TECHNICAL NOTE

LAND AT BURDELL ROAD, YAPTON, WEST SUSSEX RESIDENTIAL DEVELOPMENT

Client: Driftstone Homes Ltd
Reference: 6145

Date: July 2021

Drawing Status	FINAL		
Client	Driftstone Homes		
Project	Burdell Road, Yapton		
Drawing Title	Access Overview and Visibility Splays		
Scale	1:250	Date	July 21
Drawn By	SMO	Checked By	ALB
Drawing No.	2020-6145-001		Rev.
		I

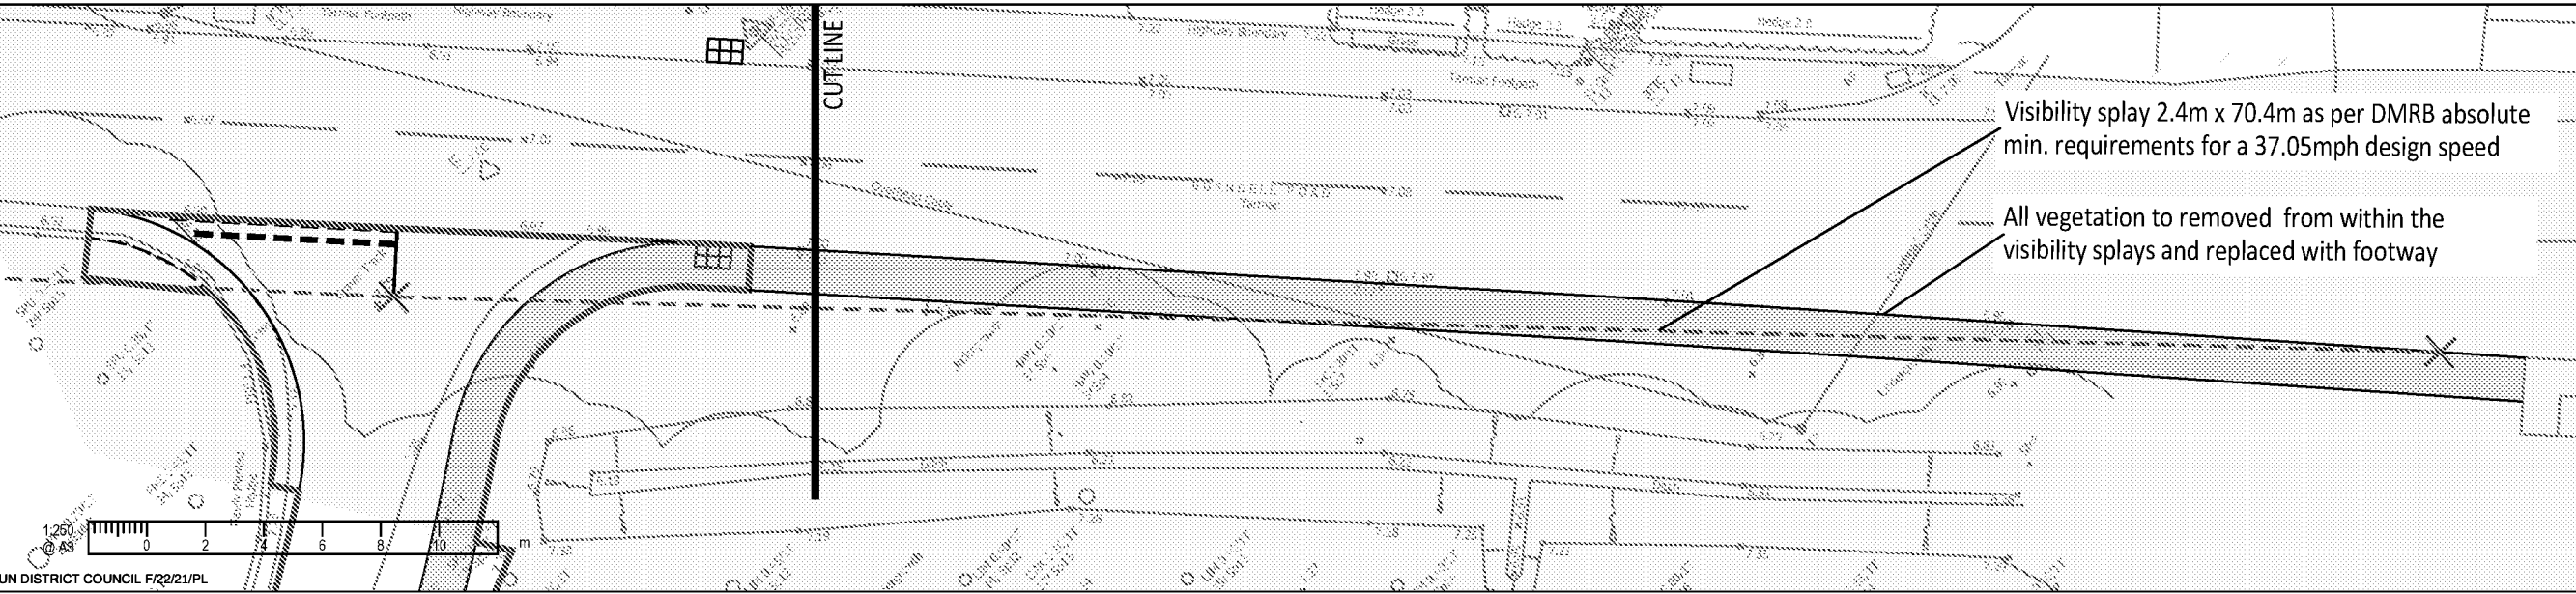
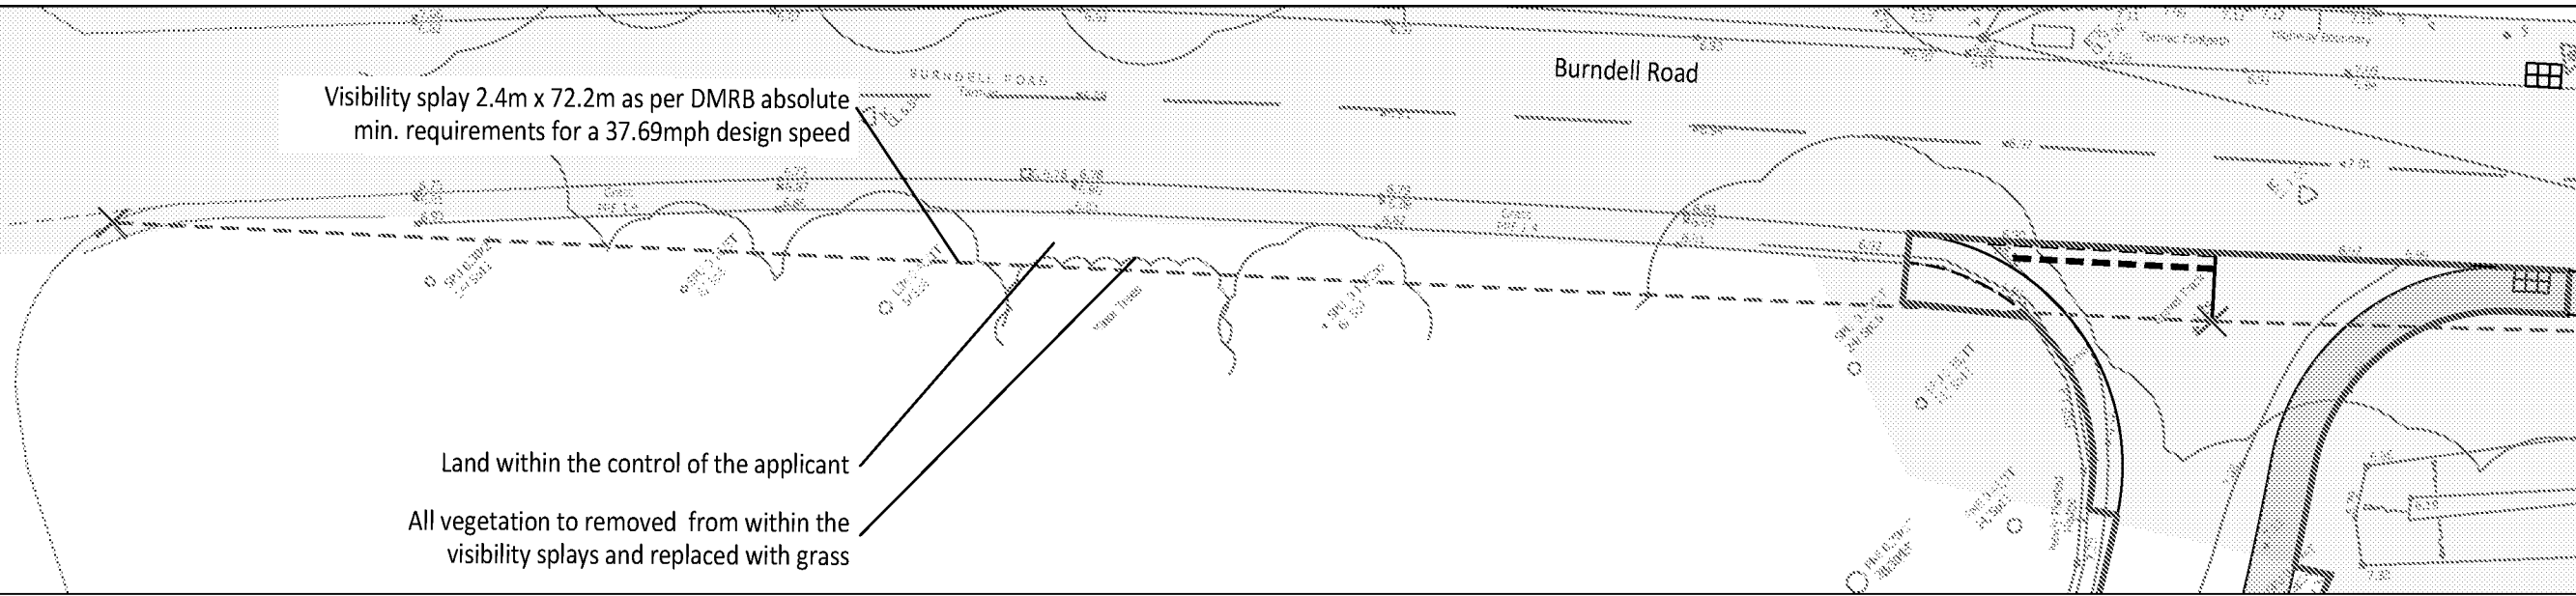
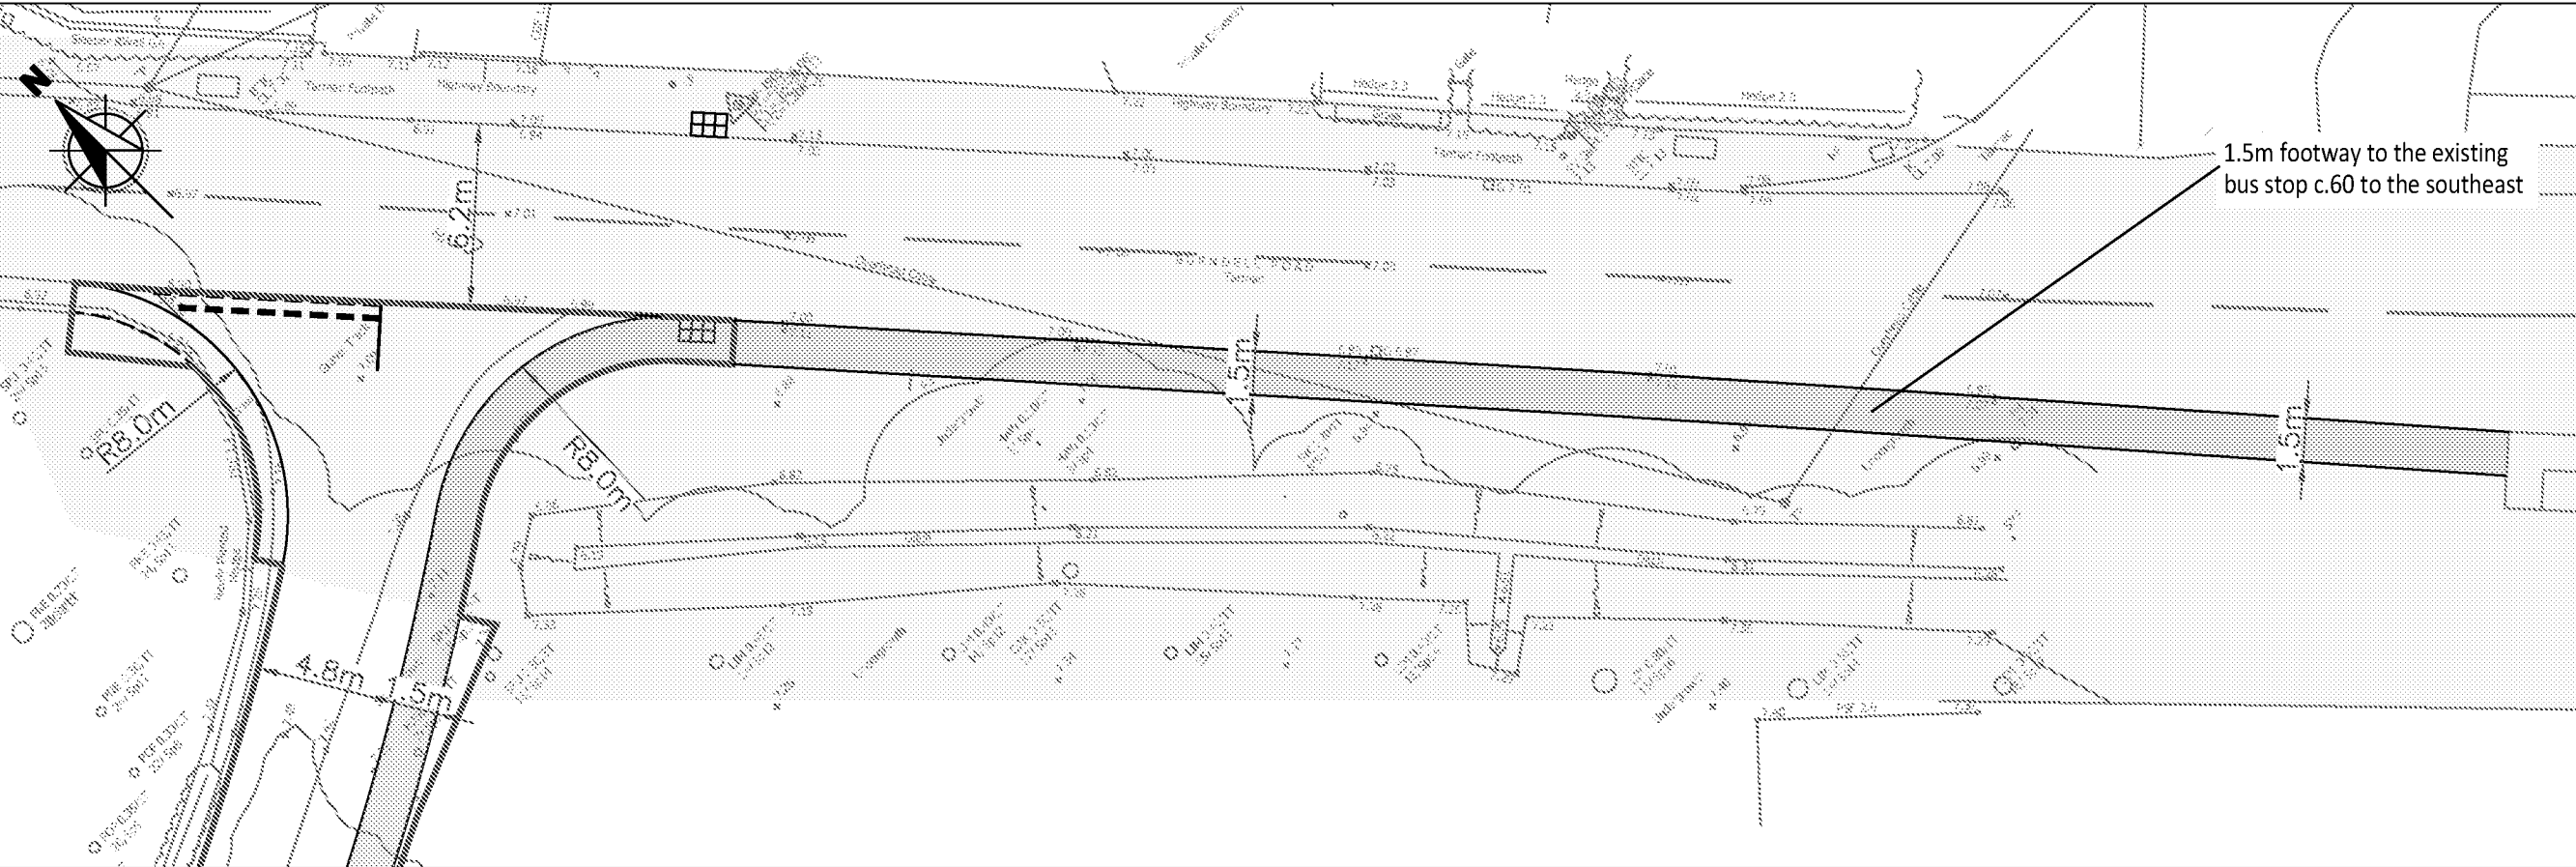
"ATC surveys taken during lockdown periods are acceptable for use in calculating 85th percentile speeds and concurrent visibility splay requirements but should not be used for traffic volume counts. The TS has taken a different approach where splays concurrent to the speed limit of 30mph and to a maximum design speed of 60kph (37.3mph) have been demonstrated. As speeds could be varying and above 37.3mph a 7-day speed survey is required to ascertain the up to date 85th percentile speeds in either direction, in vicinity of the access, along with amended vehicle visibility and pedestrian forward visibility splays in accordance with these recorded speeds."

Locations: A – The access junction onto Burndell Road (Dwg. 2020-6145-001 Rev. H)

Summary: Risk of side impact collisions due to the visibility from the access road being obstructed by vegetation.

Although the post and rail fence will require removal, and the existing vegetation will be cut back, to obtain the visibility splay in both directions from the access road, the amount of overgrown vegetation present (brambles, nettles, low tree branches etc – see photos 1 and 2) will need constant maintenance to ensure that the visibility splays are not obstructed, especially to the south-eastern side of the access junction where approaching traffic will be closest to the give way lines as vehicles exit the development. Any obstruction to visibility is likely to increase the risk of side impact collisions at the access junction.

- 2.2.2 The southbound design speed narrowly exceeds 60kph, a threshold at which DMRB CD 109 visibility requirements need to be considered. DMRB CD 109 identifies relaxations to the 'desirable minimum' stopping sight distance are permitted on Band B 60kph urban trunk roads. The low proportion of HGV's (<1%) on Burndell Road further supports relaxation from the desirable minimum as detailed in MfS 2 Section 10.1.

- 2.2.3 The secondary direction visibility splay has therefore been shown in accordance with DMRB 'absolute minimum' requirements equating to a stopping sight distance of 72.0m. The primary direction visibility splay has also been provided in accordance with DMRB absolute minimum requirements for consistency (although speeds on this approach direction fall below the DMRB 60kph threshold) equating to a stopping sight distance of 70.0m. The revised primary and secondary visibility splays are demonstrated in **Drawing 2020-6145-001**.

All vegetation, including low branches from adjacent trees, should be removed completely from within the proposed visibility splays, and replaced with either grass or a footway (to the south-east – see recommendation to problem 2.2).
